**Application by Cory Riverside Energy for an Order Granting Development Consent for the Riverside Energy Park.**

**Additional Written Questions**

**Q2.1.4 – Please will the London Borough of Havering comment on the Applicant’s assessment of the significance of the predicted impacts from air emissions, in particular Nickel and Chromium VI, at identified receptors in Rainham as set out in its response to the ExA’s first written questions [REP2-055]**

**London Borough of Havering response**

Predicted Annual Mean Chromium VI Concentration - Maximum Emission Concentration

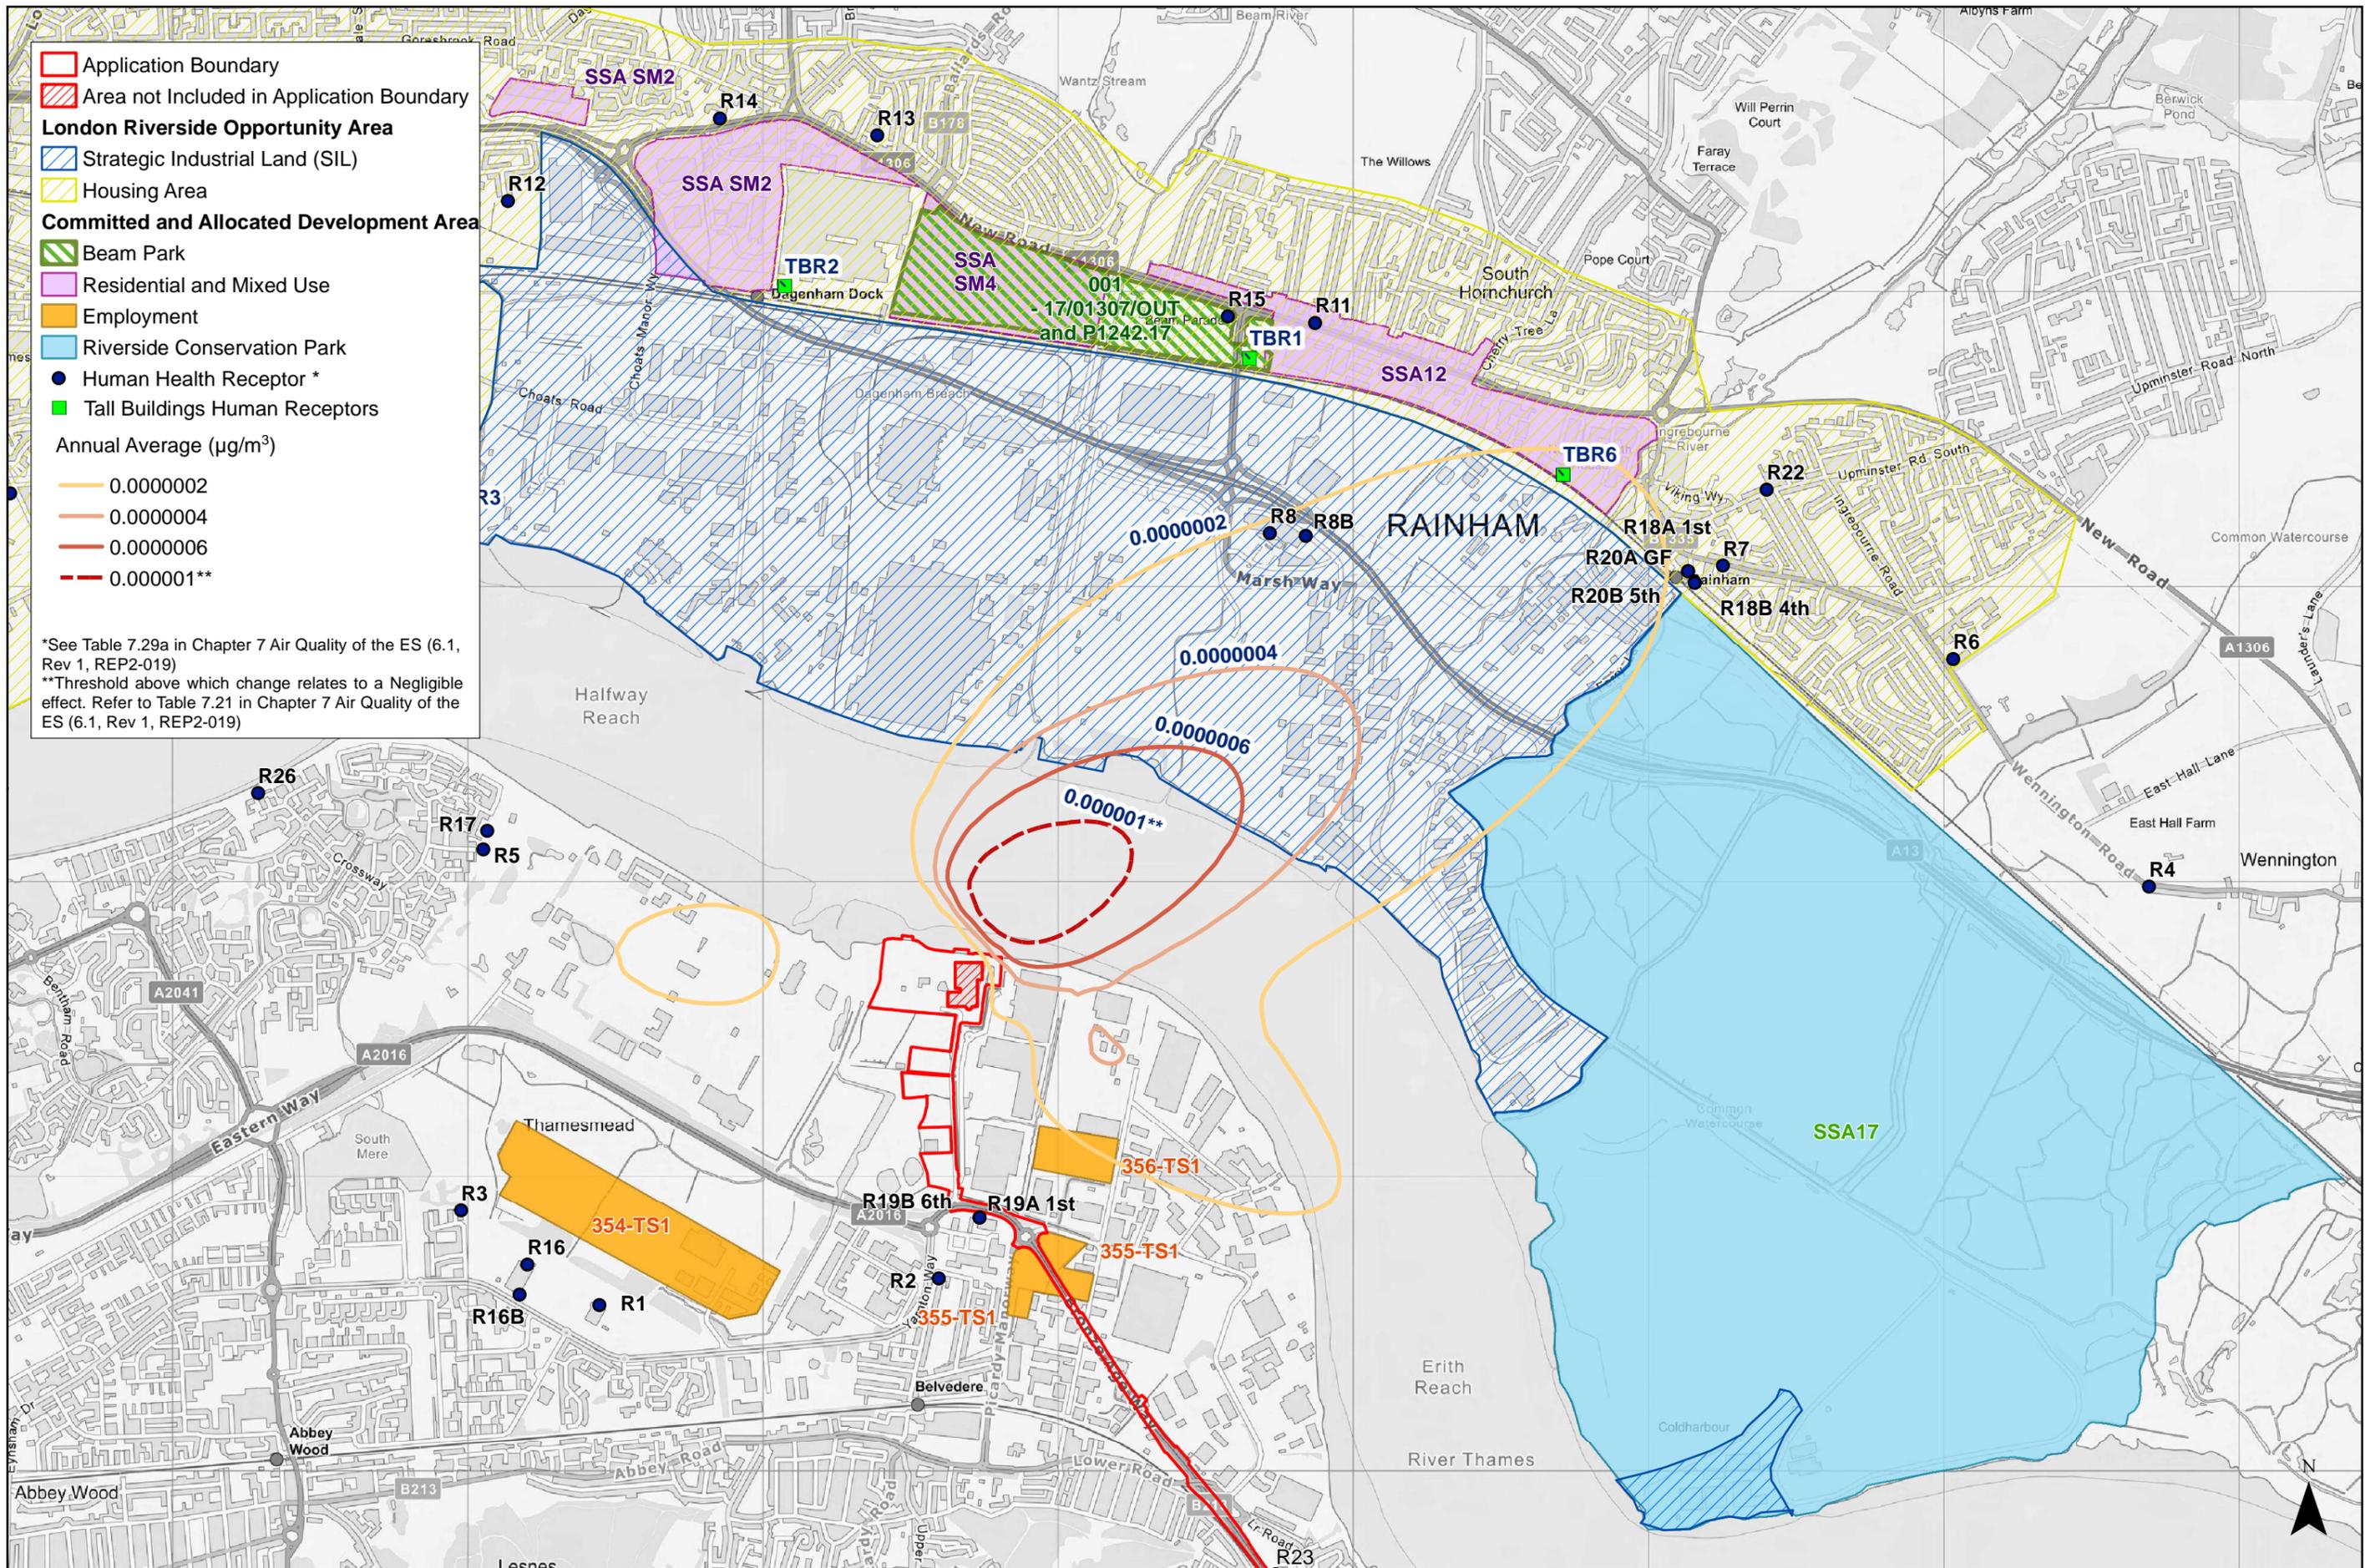
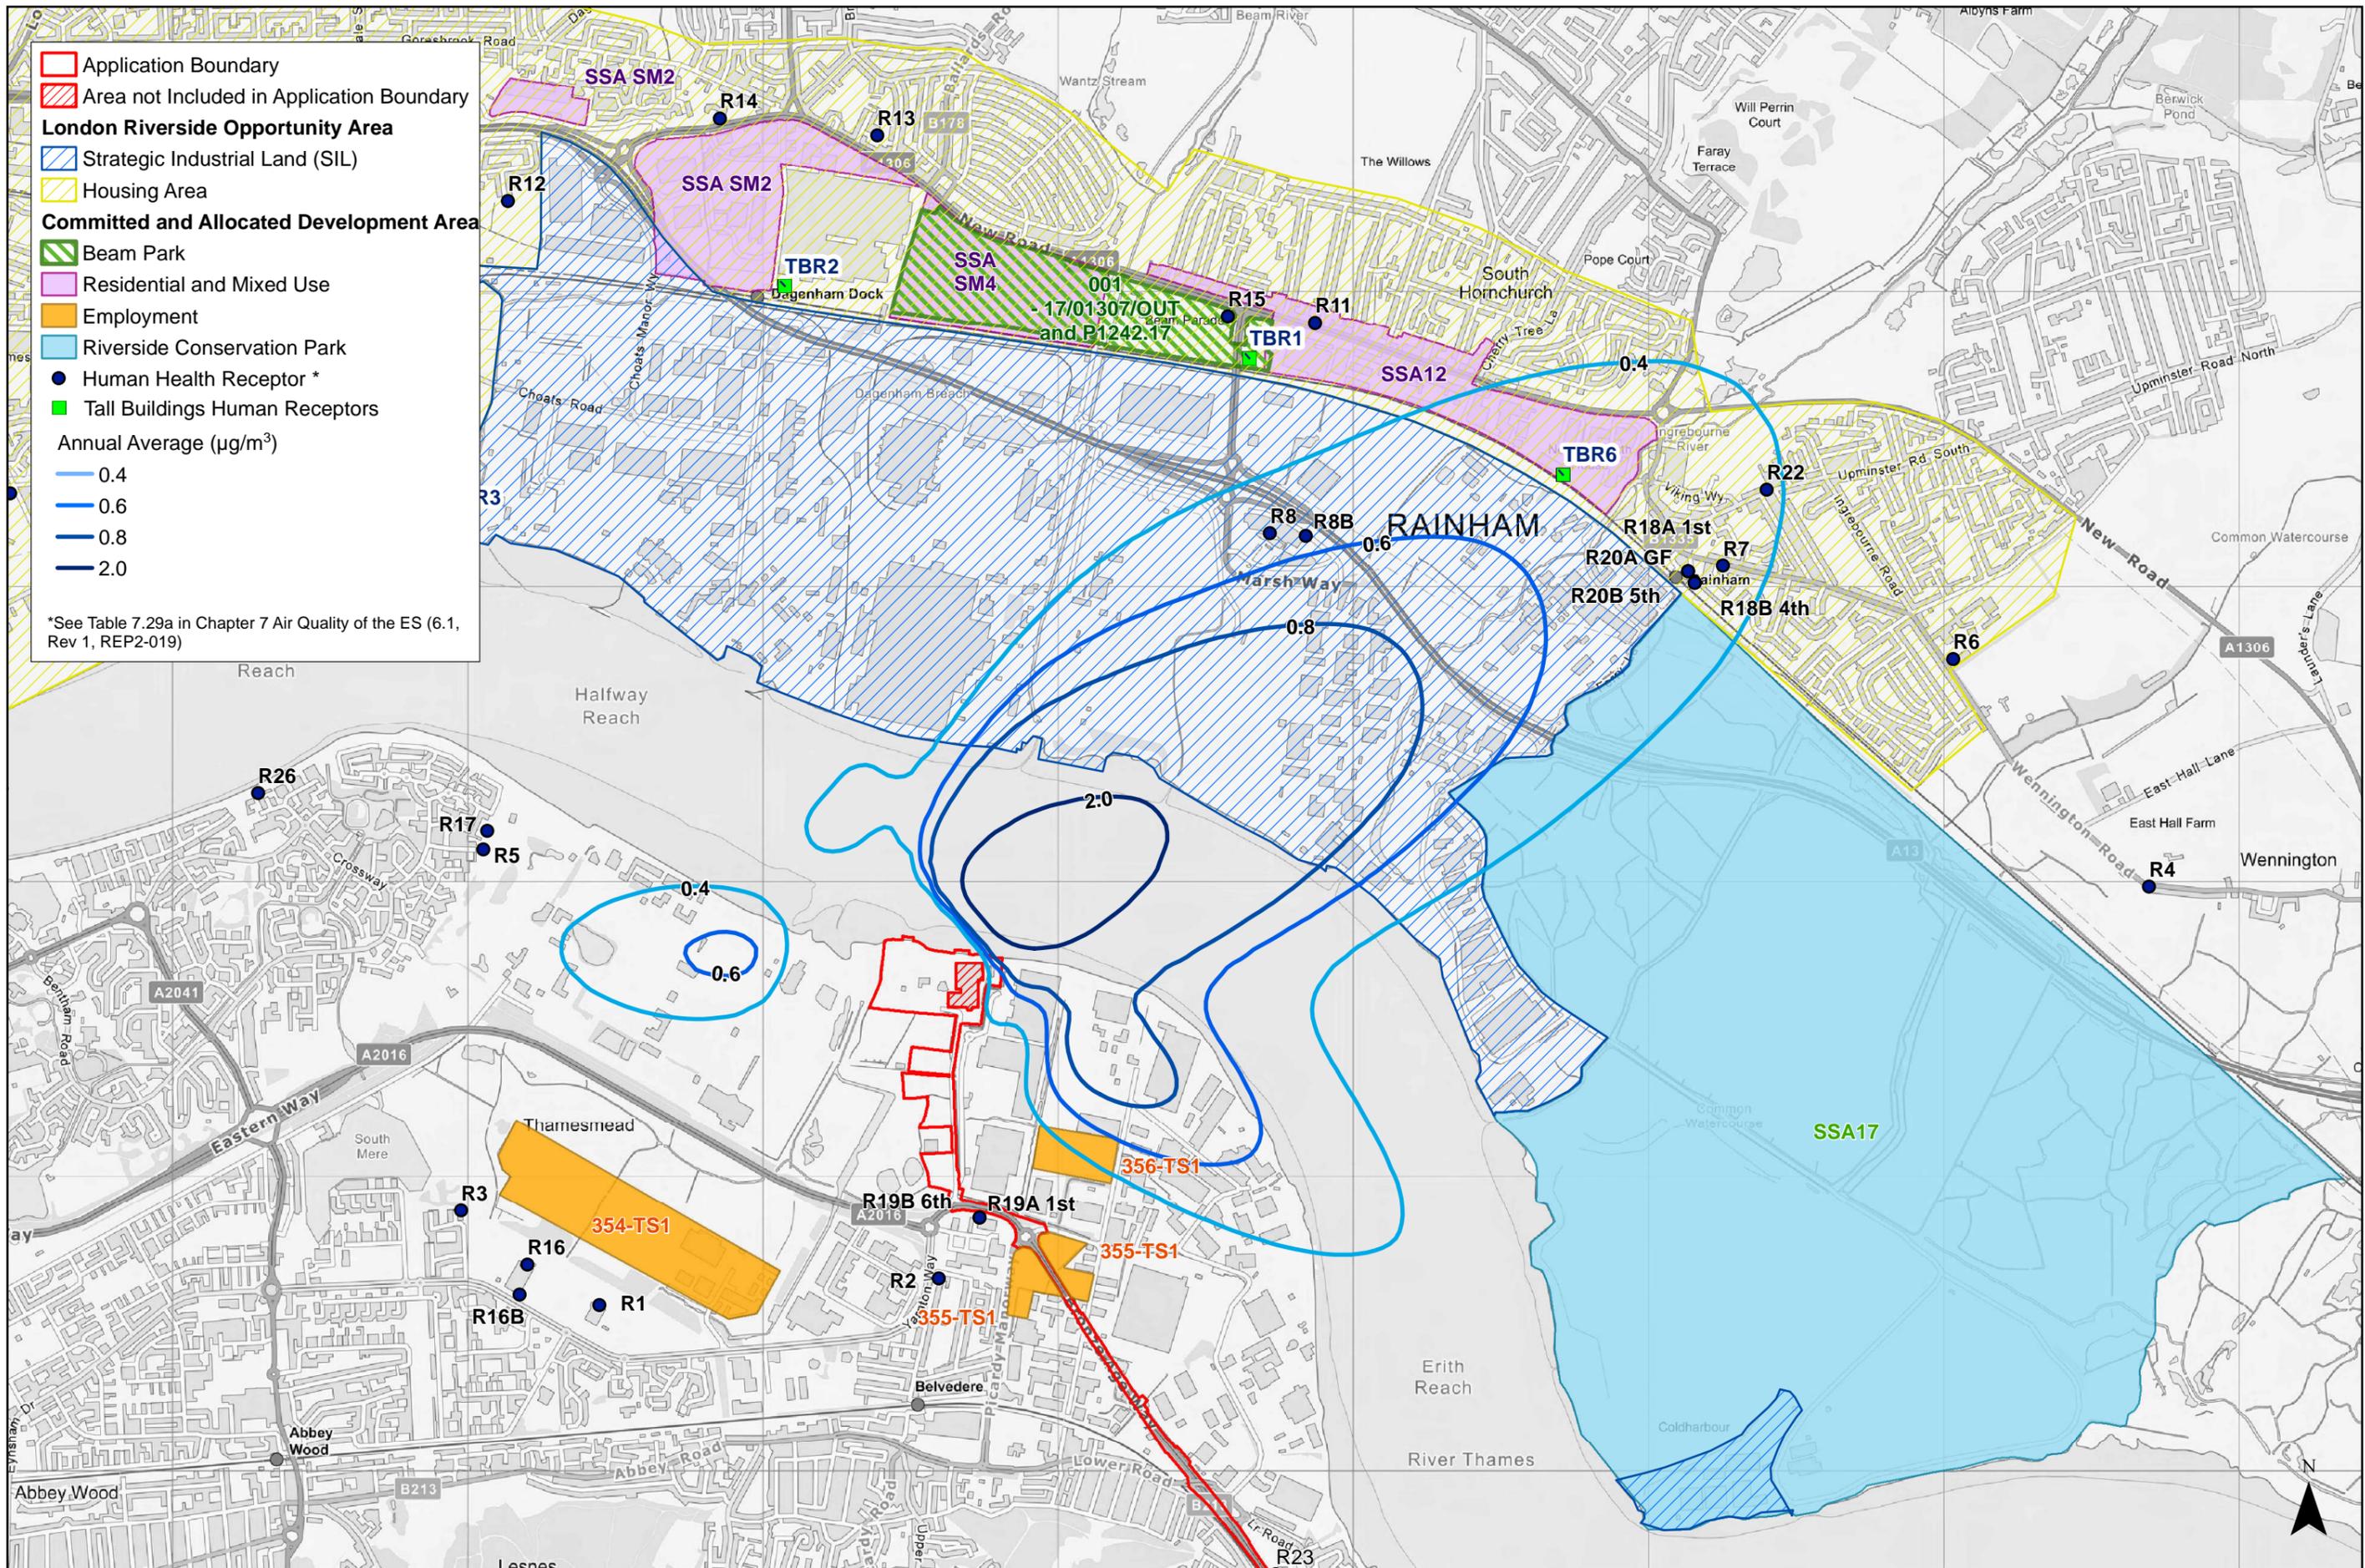
2.1 The Applicant has described the degree of impacts as Negligible, based on the fact that the incremental change in Chromium VI concentrations as a result of the proposed development is less than 0.5%. Based on this description, the Applicant has assessed the impacts from Chromium VI concentrations as not significant.

2.2 While the above description of impacts is in accordance with the suggested framework for describing the impacts set out in the IAQM guidance, the guidance states that *'It is unwise to ascribe too much accuracy to incremental changes or background concentrations, and this is especially important when total concentrations are close to the Air Quality Assessment Level (AQAL)'*. According to the same guidance, *'As the exposure approaches and exceeds the AQAL, the degree of harm increases. This change naturally becomes more important when the result is an exposure that is approximately equal to, or greater than the AQAL'*.

2.3 Taking into account that the predicted range of change in Chromium VI concentrations is 0.32 to 0.36% as well as the inherent uncertainty associated with these predictions, the Council considers that the likelihood of an incremental change of greater than 0.5% cannot be ruled out. Taking also into consideration the fact that a high number of human health sensitive receptors are exposed to Chromium VI concentrations which already

significantly exceed the AQAL (over 160% of the AQAL), the Council assesses the impacts from Chromium VI emissions as potentially significant.
